**RE: American Gypsum Recycle Plant
Grading Plan
Stamp Date: 2/27/17
Hydrology File: D17D108**

Based upon the information provided in your submittal received 3/9/2017, the Grading Plan **is not** approved for Building Permit and Grading Permit. The following comments need to be addressed for approval of the above referenced project:

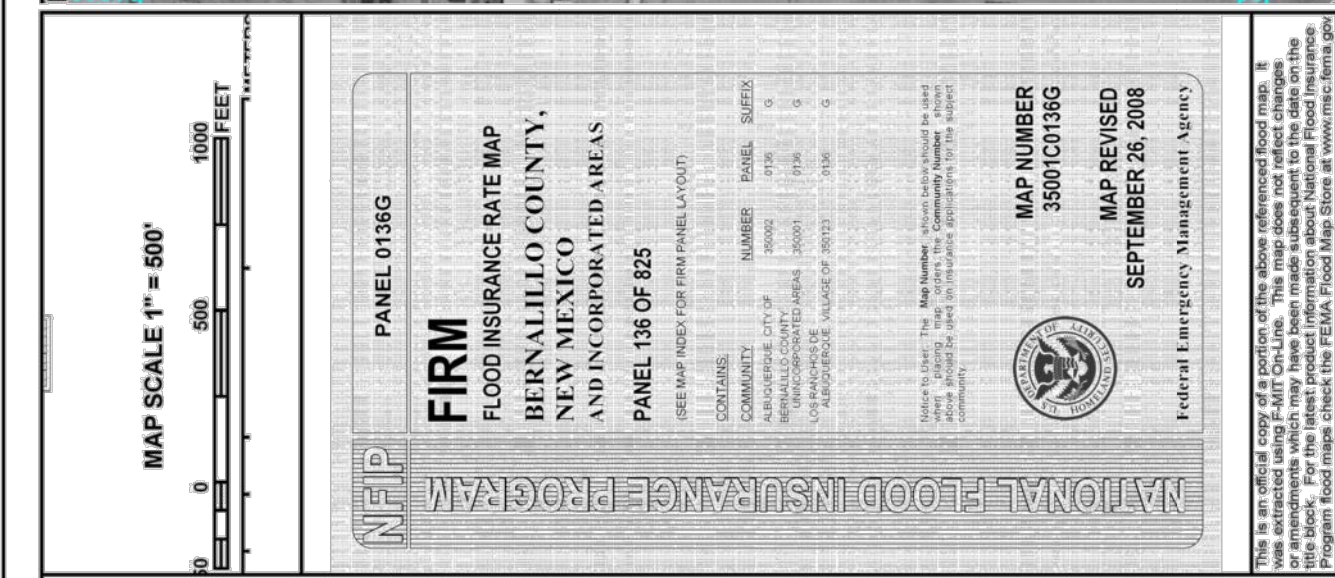
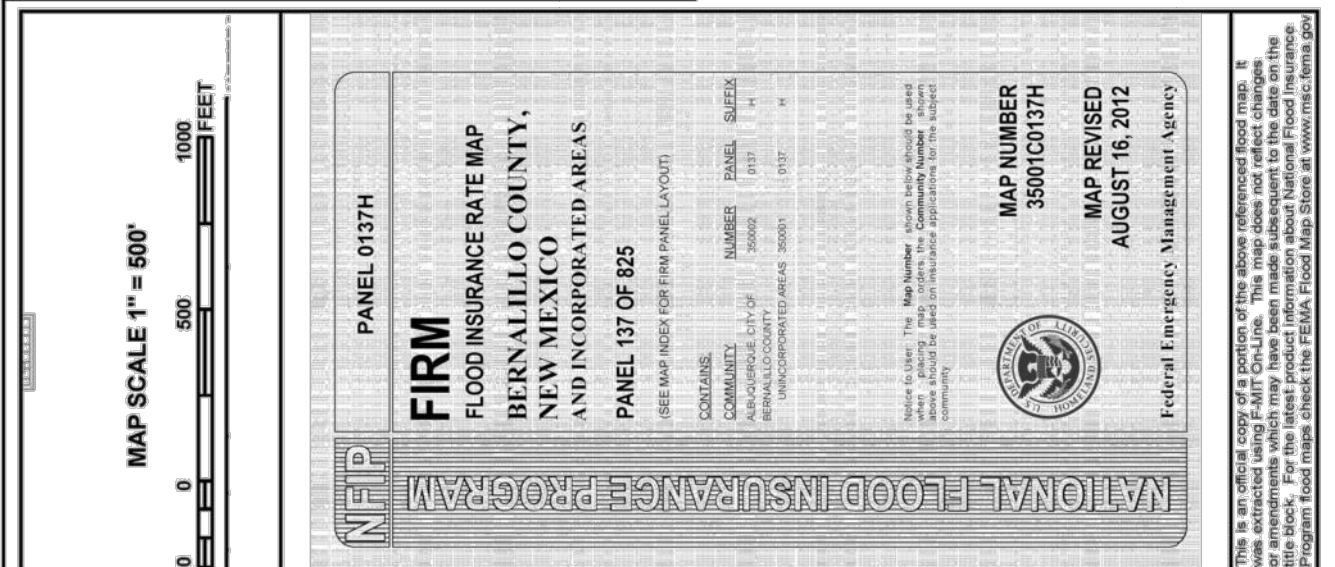
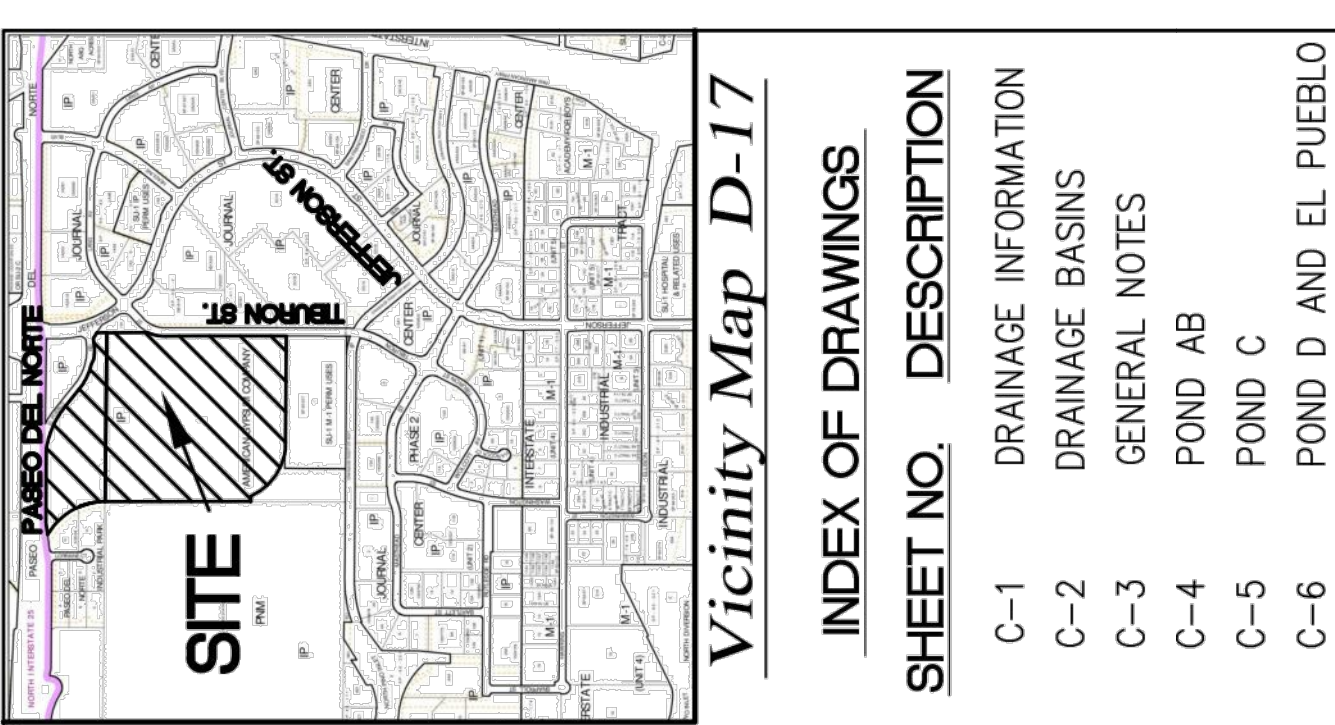
1. Using the existing contours around the proposed development, it appears that the runoff for this development drains towards Pond "C" and not Pond "D". If the proposed development runoff is to drain towards Pond "D", then you need to show how this to be accomplished.
2. First flush volume needs to be calculated and shown on this sheet, as well as how it will be retained in either Pond "C" or "D" whichever pond the runoff is to be draining towards. The first flush volume should be captured in the pond beneath the invert of the outlet structure.
